RESPONSE TO IPC SSD 10371 – TRINITY GRAMMAR SCHOOL

This Letter has been prepared by Willowtree Planning Pty Ltd on behalf of Trinity Grammar School, in relation to SSD 10371, being the State Significant Development Application (SSDA) for the Trinity Grammar School Redevelopment.

Specifically, this Letter is provided in response to the Request for Information (RfI) from the Independent Planning Commission (IPC), dated 16 August 2021 (refer **Appendix 1**). Attachment A of the RfI lists the matters on which an Applicant response has been requested.

PROJECT	TGS Renewal Project	PROJECT #	2808
CLIENT	Trinity Grammar School	DWG #	DA140
DWG	Proposed Maintenance Plan B1	SCALE	1:200 @ A1
CLIENT REF & CONTACT	119 Prospect Rd, Summer Hill	DATE	Feb 2020
		DRAWN	KC
		CHECKED	SC
		REVISION	E

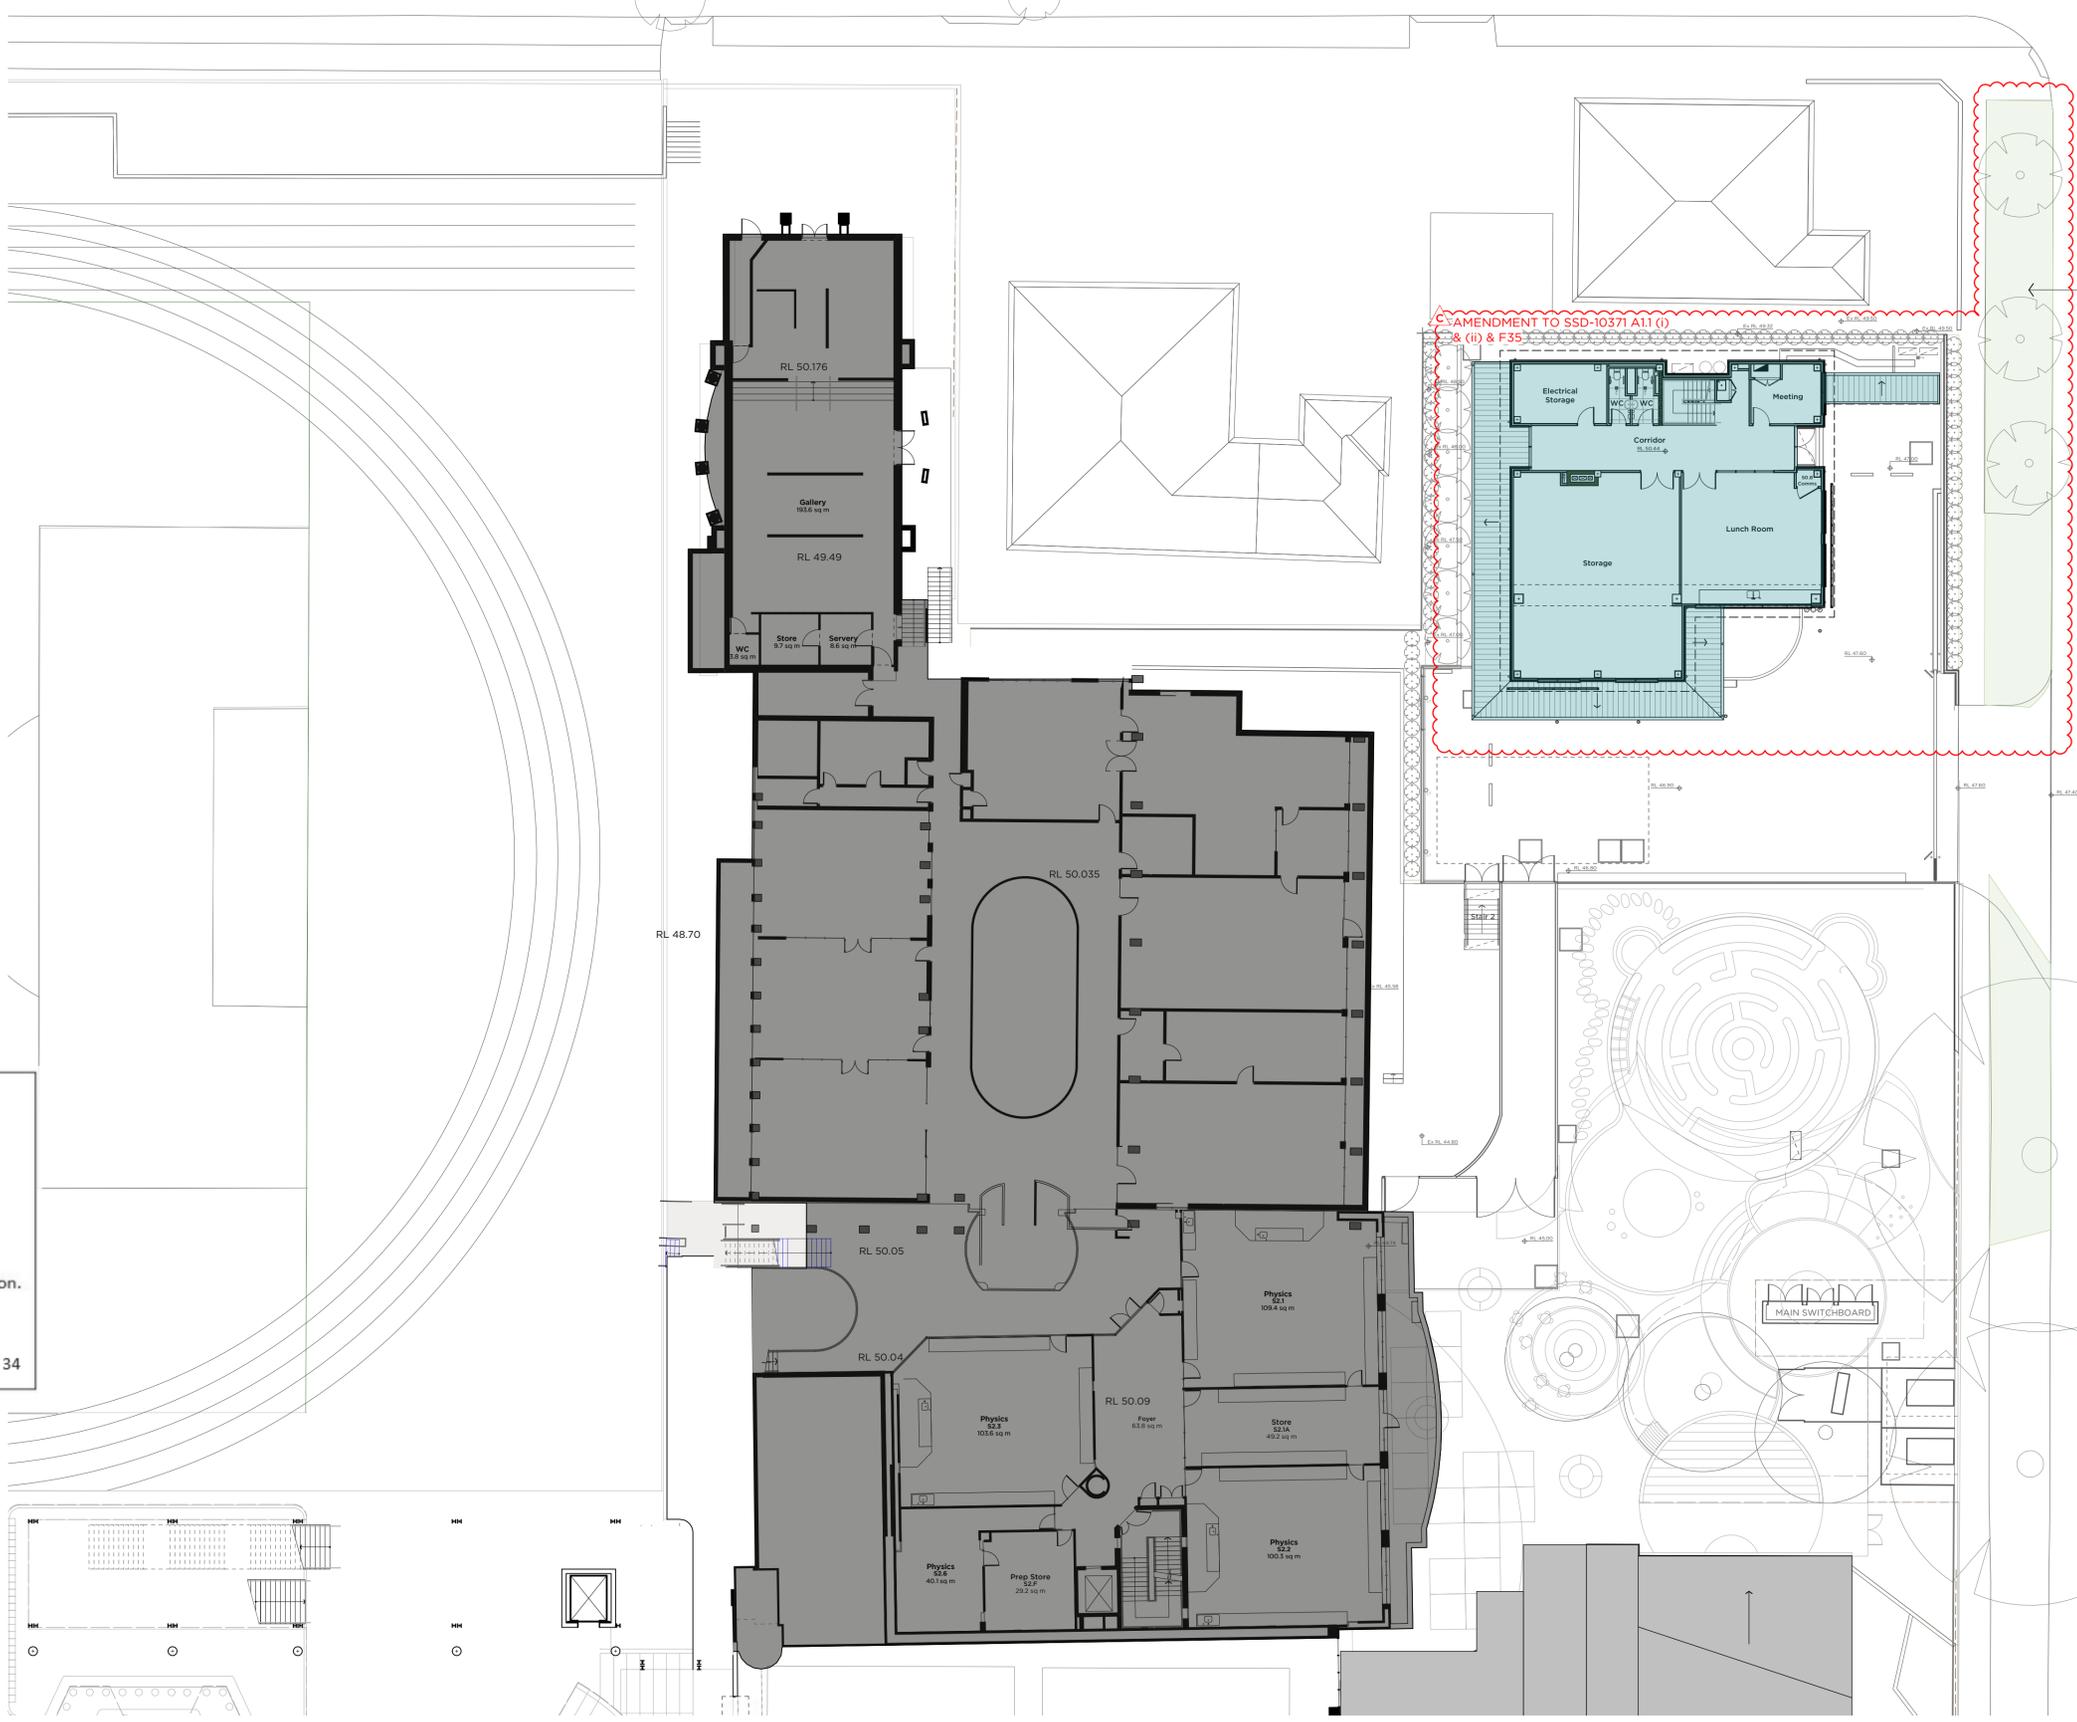
8. Latest car park plans (at a scale no less than 1:200), including RL heights.

10. Location and schematic design (including heights) of the exhaust structure servicing the car park.

Plans of the proposed carpark, and details of the Jubilee Drive carpark and access, are provided within the Architectural Drawings at **Appendix 2**, Design Statement at **Appendix 3**, and Architectural Presentation at **Appendix 4**.

- Finalisation of the mechanical exhaust system. A 2.4m high exhaust plenum has been developed at the south western corner of Oval 3. This plenum will be a masonry block structure to match existing retaining walls along the nature strip backing to Victoria Street.
- Layout update to grounds and storage area.
- Introduction of new egress path at the north western corner of the Oval 3 carpark to significantly improve egress strategy.
- Updated carpark layout across two (2) ovals (noting that the overall strategy and general layouts remain the same).

The location of the mechanical exhaust for the carpark is shown in the Site Plan at **Appendix 5**.

A 2.4m high exhaust plenum has been developed at the south western corner of Oval 3. This plenum will be a masonry block structure to match existing retaining walls along the nature strip backing to Victoria Street.

PROJECT	TRINITY GRAMMAR SCHOOL	PROJECT #	2808
CLIENT	THE RENEWAL PROJECT	DWG #	
	Trinity Grammar School		
DWG	Building Sections-Seaview Maintenance		DA309
CLIENT REF & CONTACT	119 Prospect Rd, Summer Hill	DATE	Jan 2021
		SCALE	1:100(A1)
		DRAWN	KC
		CHECKED	SC
		REVISION	C

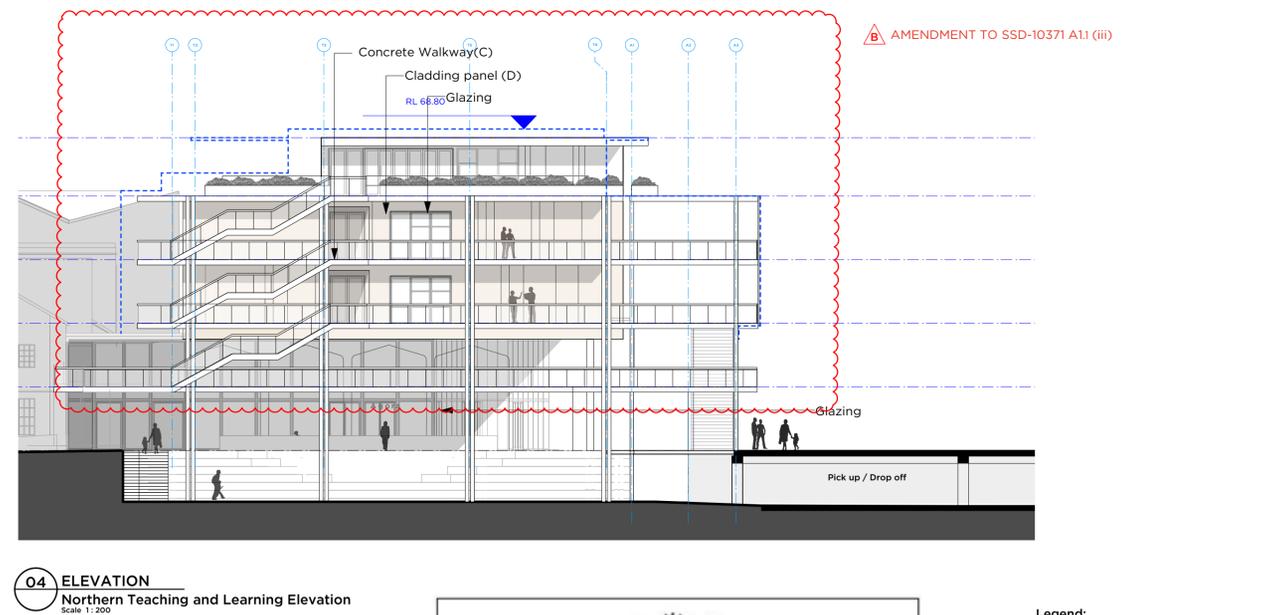
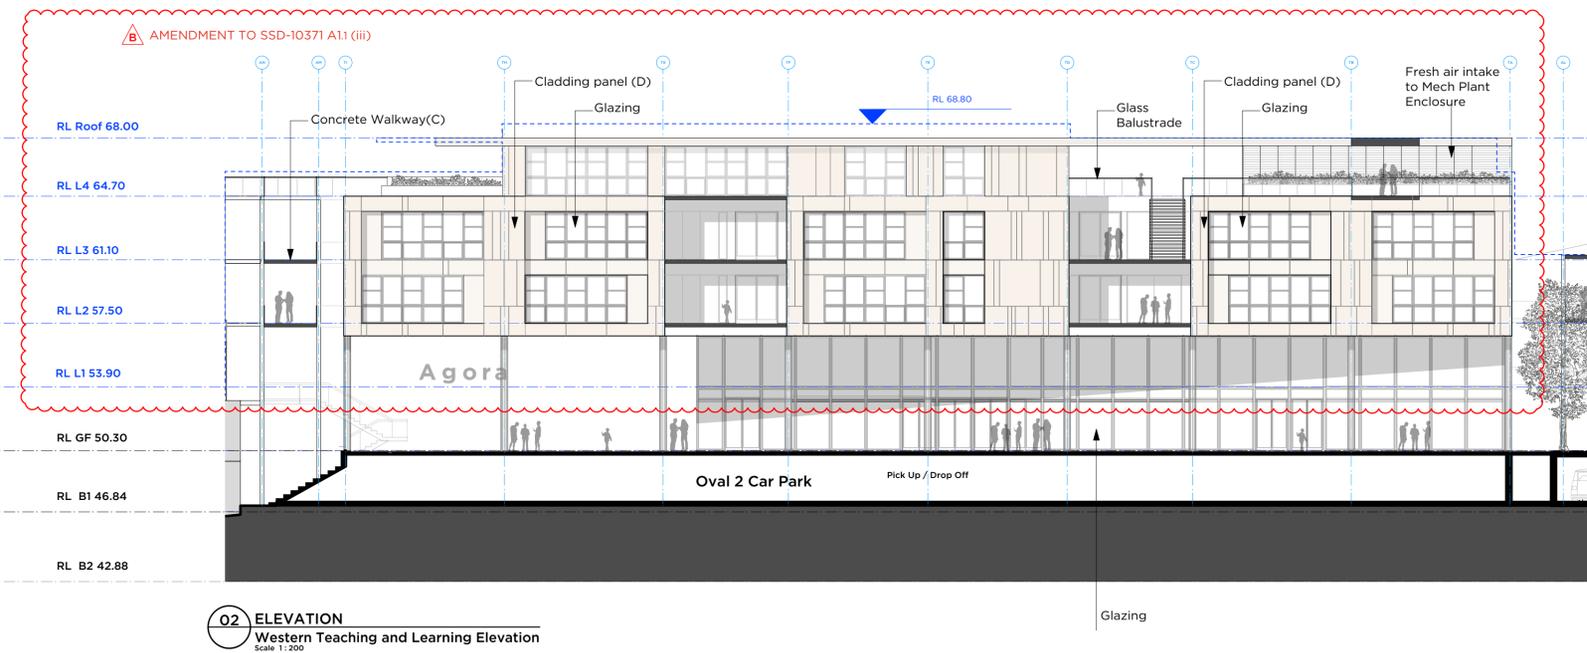
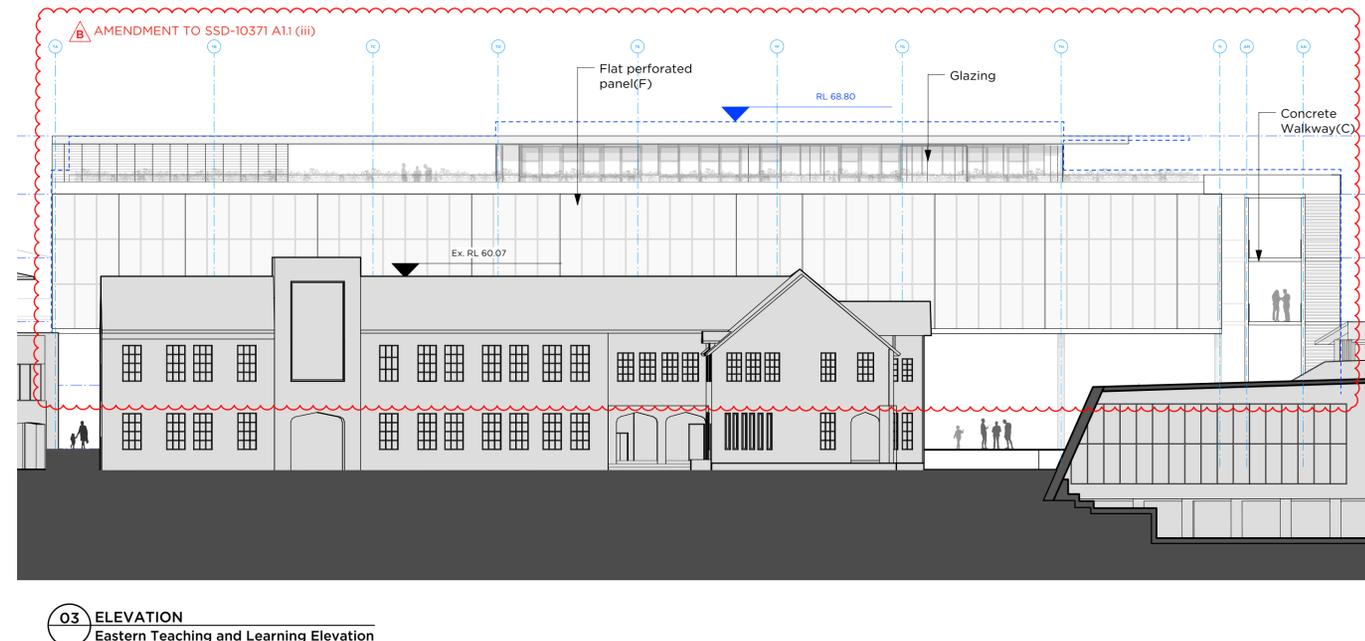
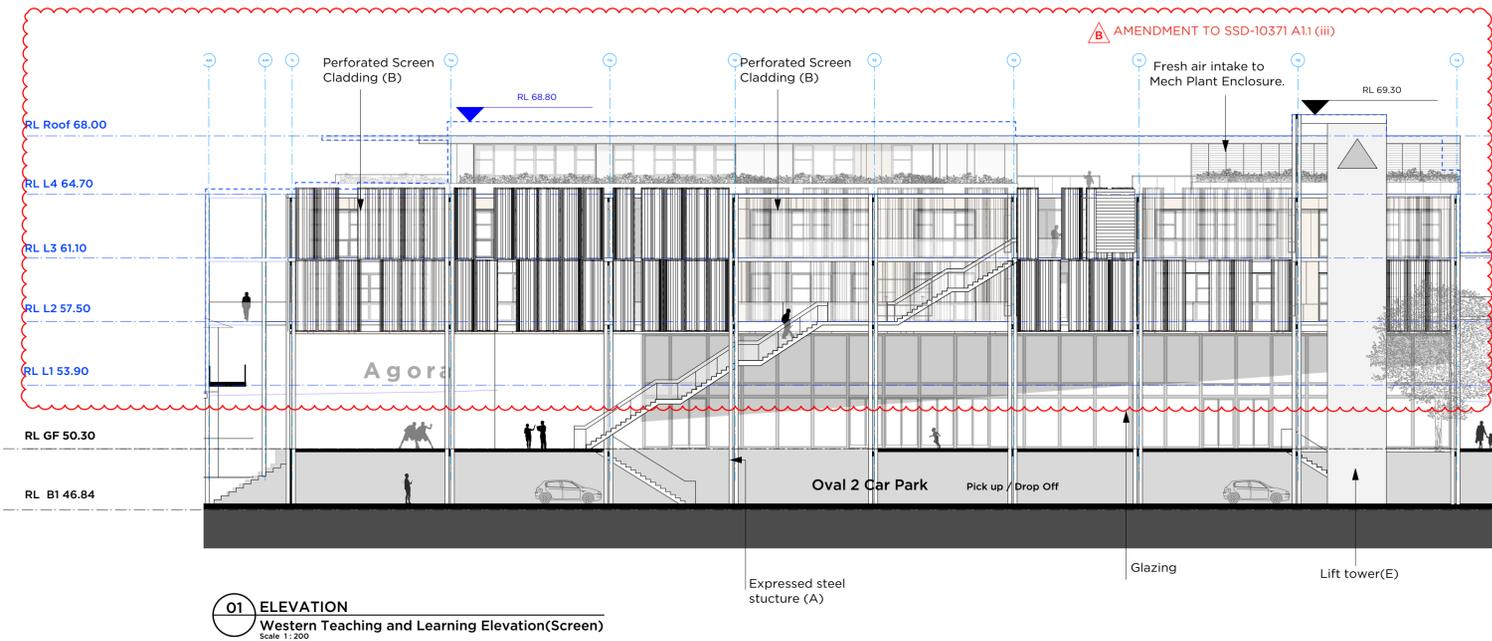
18.1. Section 4.4 Shading and Daylight of the ESD Report states: "Preliminary PMDL concept indicates elevation facing Victoria street for west wings are provided with shading element of consisting of perforated mesh. The external shading scheme helps increase natural daylight...." Question: If the screens are shading elements how do they increase natural daylight?

The aim of including a shading device is to allow for indirect natural daylight to penetrate into the teaching environment for the entire teaching day whilst providing a restriction against direct solar loads that will impact this western exposure late in the teaching day.

This approach was deemed the best project strategy in lieu of either tinted glazing (that permanently limits visible light) or operable shading devices for peak time use (which typically fail over time and impose unwanted thermal loads on classrooms). The strategy chosen balances the competing interests of permitting visible light penetration, and exclusion of unwanted solar gains.

01 ELEVATION
Multipurpose Pavilion North Elevation
 Scale 1:200

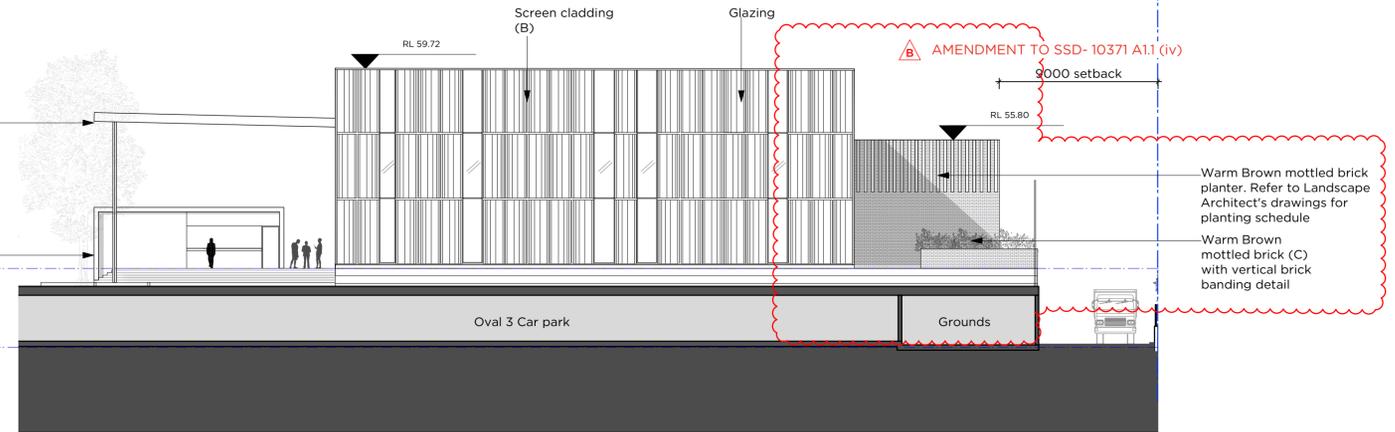
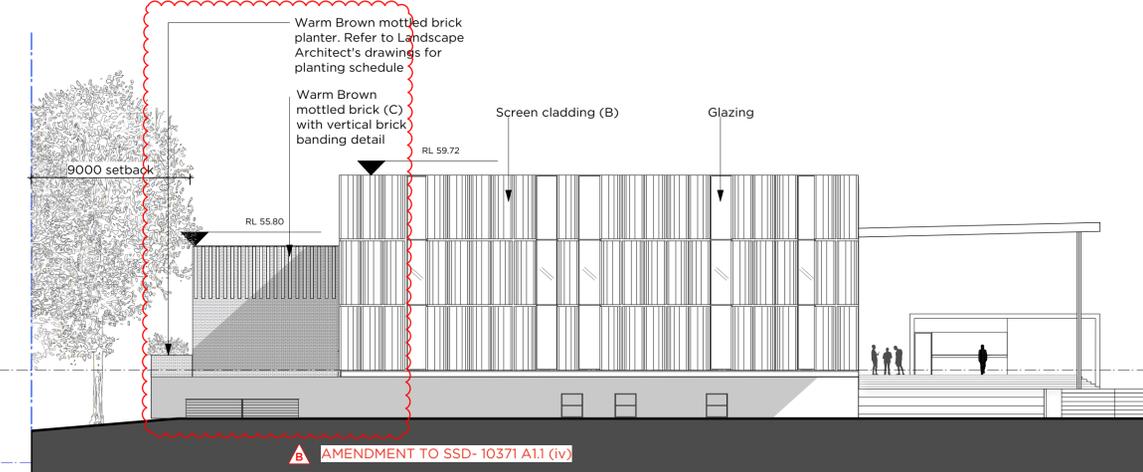
2. Annotated elevations (at a scale no less than 1:200) of all new building facades indicating detail of materials. Elevations should not only describe the proposed screen and framed armature but also (separately) the proposed design of the elevation behind the screen.

Detailed, annotated Architectural Elevations are provided within the Architectural Drawings at **Appendix 2**.
